LSC Responses to TIS Redline Comments

Mr. Jeff Mark
Ridges at Lorson Ranch

August 13, 2021
Traffic Impact Analysis

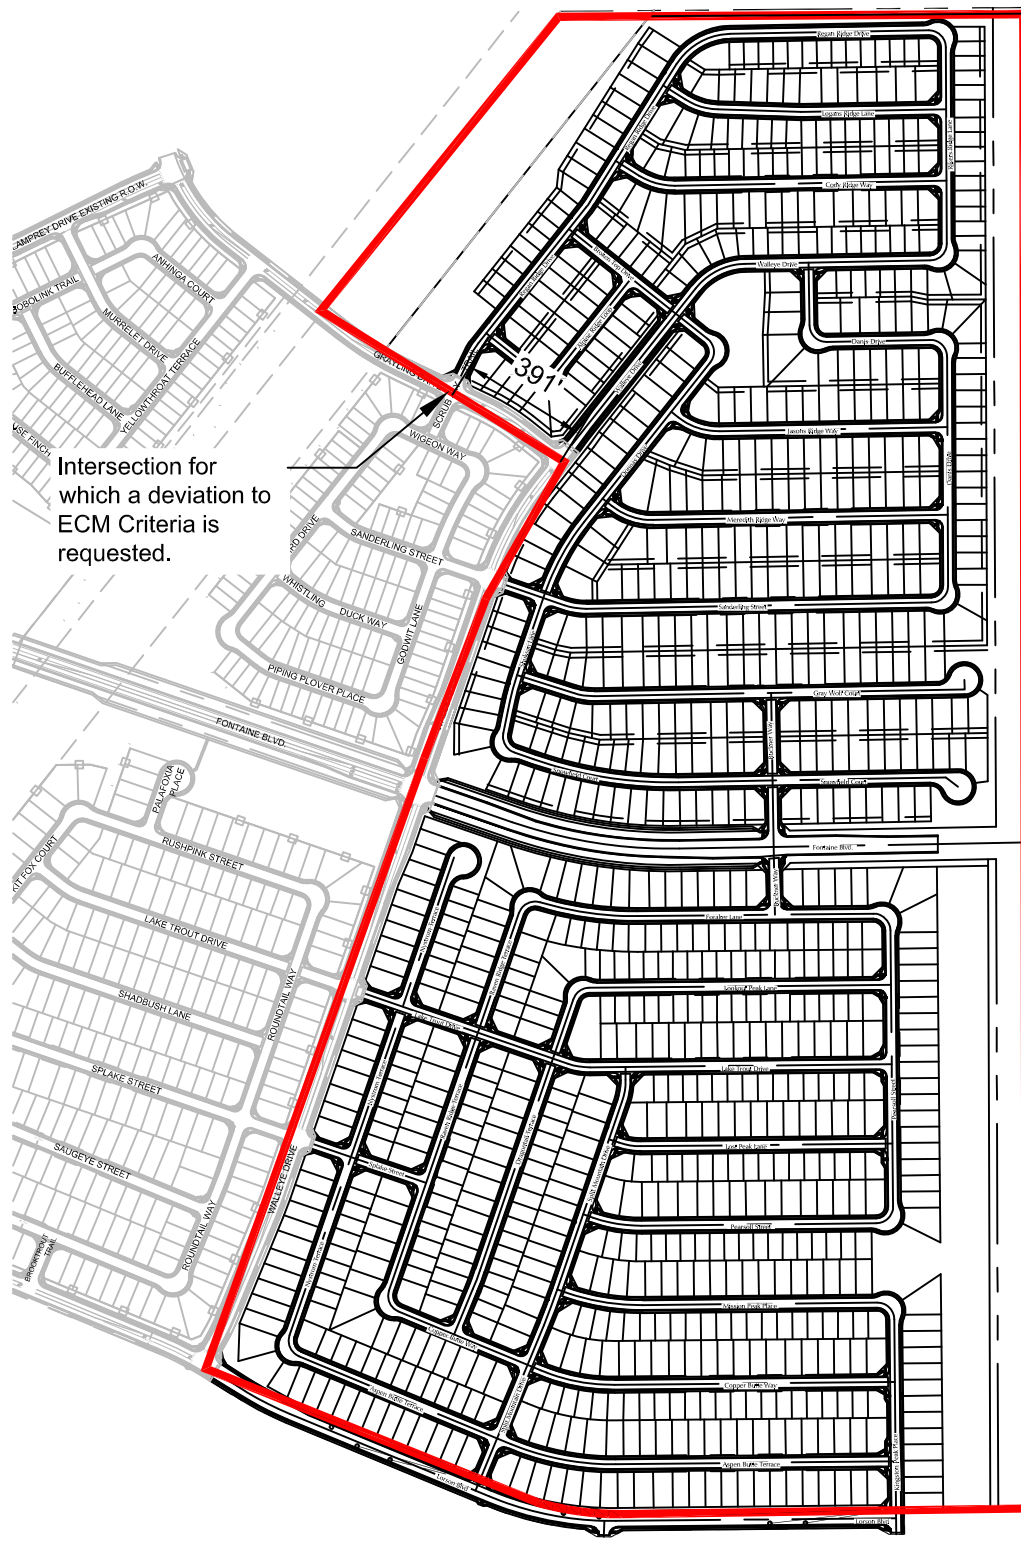
[State whether certain signage is recommended for westbound traffic](#)

LSC Response: A statement about additional signage has been added as requested.
